**RE: Section 73 Variation of Condition Application: Proposed Variation of Condition 2 pursuant to Planning Permission EP/157/20/HH at The Breakers, 29 Tamarisk Way, East Preston, BN16 2TE.**

**Proposed Variation of Condition 2 pursuant to Application Reference EP/157/20/HH**

Proposed Ground Floor Plan
1469/NA15A
Scale 1:100 at A3 .

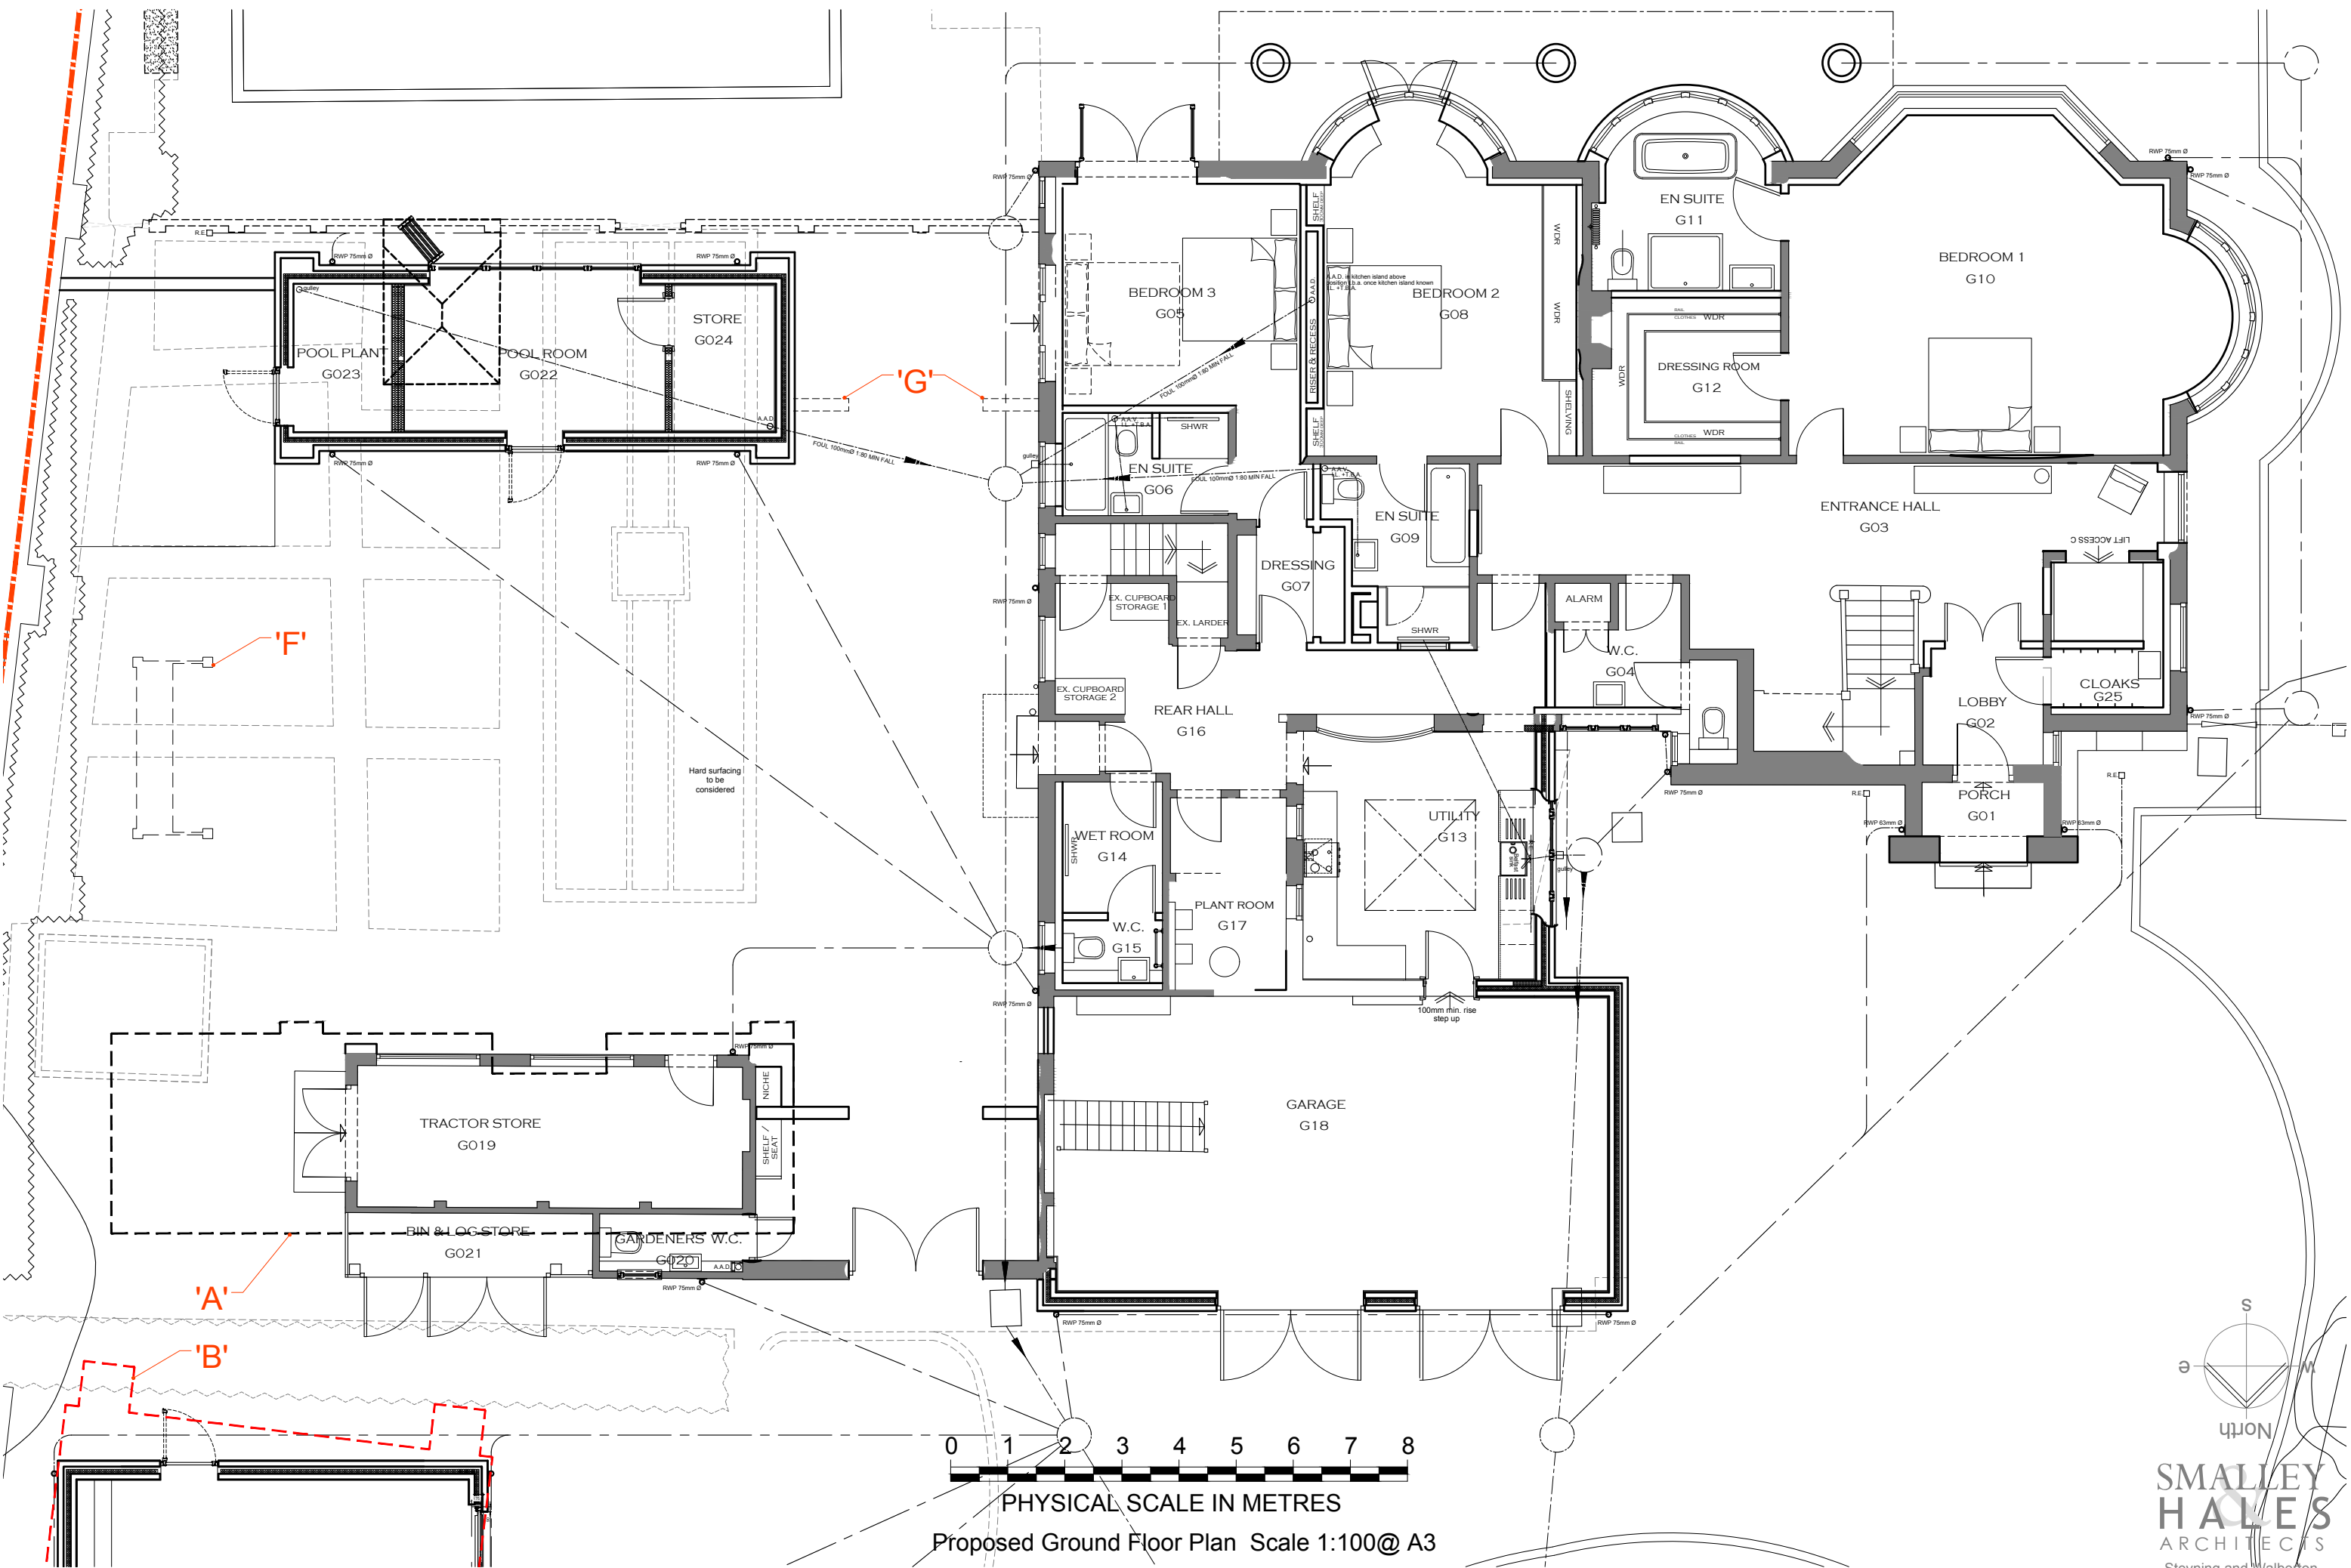
- A. Retention of original outbuilding, to the south of the garage, rather than the approved enlarged outbuilding.
- B. Slight change in the orientation of the garage.
- C. Removal of a chimney.
- D. Introduction of a small catslide roof portion on the western elevation.
- E. Removal of browed eaves above windows to become flat eaves.
- F. Removal of covered bench building.

In addition to the above, the proposals would seek to revert to the existing rainwater drainage below ground rather than soakaways due to the reduction in footprint.
